Arun District Council
Arun Civic Centre
Maltravers Road
Littlehampton
West Sussex BN17 5LF
Planning & Building Control General Enquiries
Tel: (01903) 737756 Fax: (01903) 730442
Dx: 57406 Littlehampton
Minicom: 01903 732765
e-mail: planning@arun.gov.uk
website: www.arun.gov.uk/planning

Application No: R/89/21/HH
Site Address: 74 The Martlets Rustington BN16 2UE
Description of works: Erection of a timber single storey granny annexe for ancillary use to the main dwelling.

Thank you for your internet representation made on 21st May 2021 which has been recorded as an objection with the comments as follows:

East Elevation

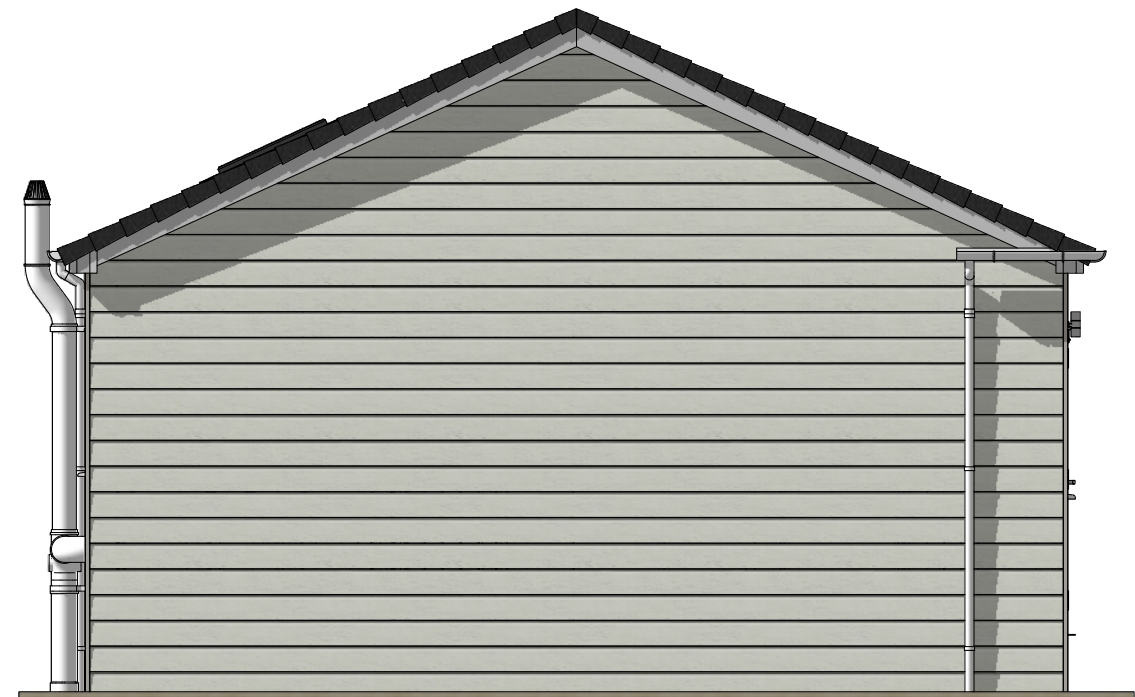
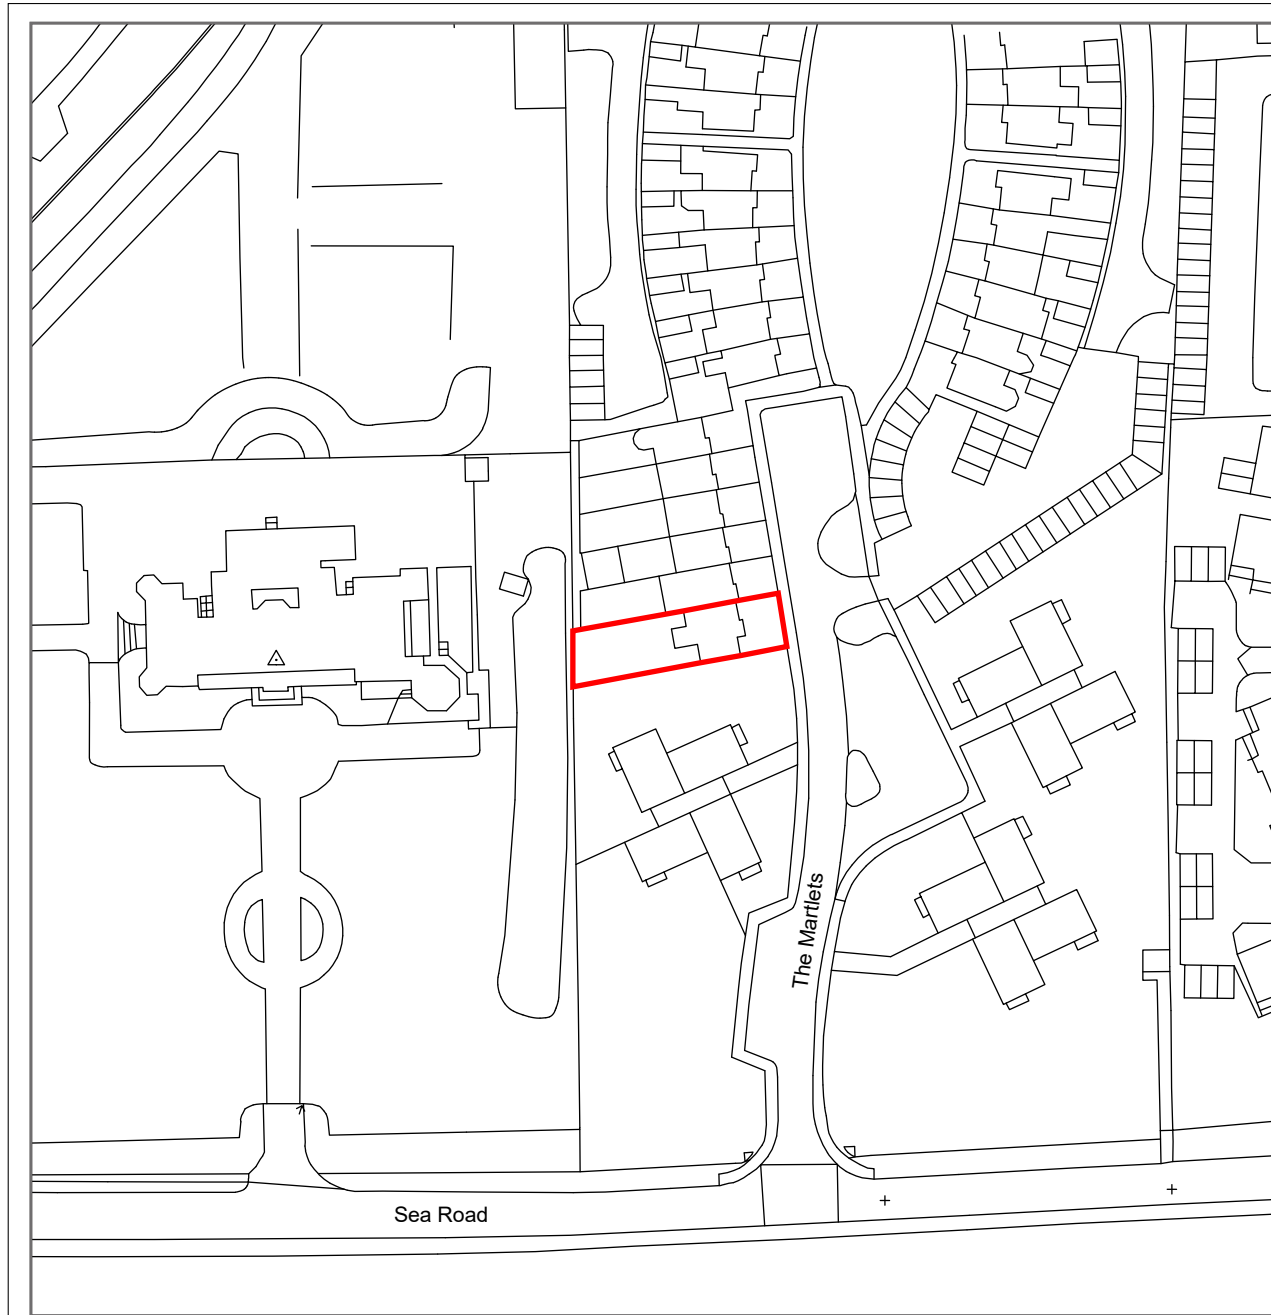
Due to the planned roofing style of this building, it would end up being greater than 2.5m high and would cause a drastic light reduction to the neighbouring gardens and be a blot on the landscape as well as disrupting the neighbours view of the sea.
